**WELWYN HATFIELD BOROUGH COUNCIL
EXECUTIVE DIRECTOR - PLANNING, PUBLIC PROTECTION AND GOVERNANCE**

Application No: 6/2017/1662/ADV
Location: 25 Station Road Cuffley Potters Bar EN6 4HX
Proposal: Retention of 8 x 2 m tall non-illuminated freestanding banner advertisements
Officer: Mr David Elmore

Recommendation: Refused

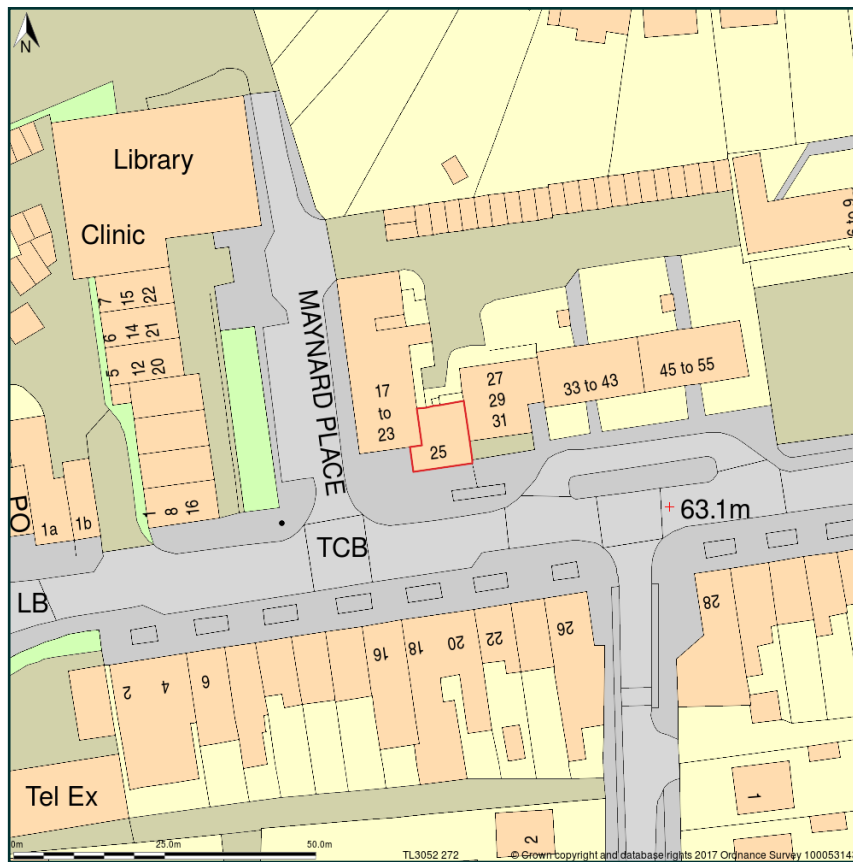
Conclusion	
<p>The application site on submitted Site Plan - with Unique Plan Reference: #00245326-7CAA5C, does not surround the area where the flag advertisements are being displayed. The absence of a correct site location plan means that this application cannot be considered and must be refused on the basis of inaccurate information.</p>

1. The red line which identifies the application site on submitted Site Plan - with Unique Plan Reference: #00245326-7CAA5C, does not surround the area where the flag advertisements are being displayed. The absence of a correct site location plan means that this application cannot be considered and must be refused on the basis of inaccurate information.
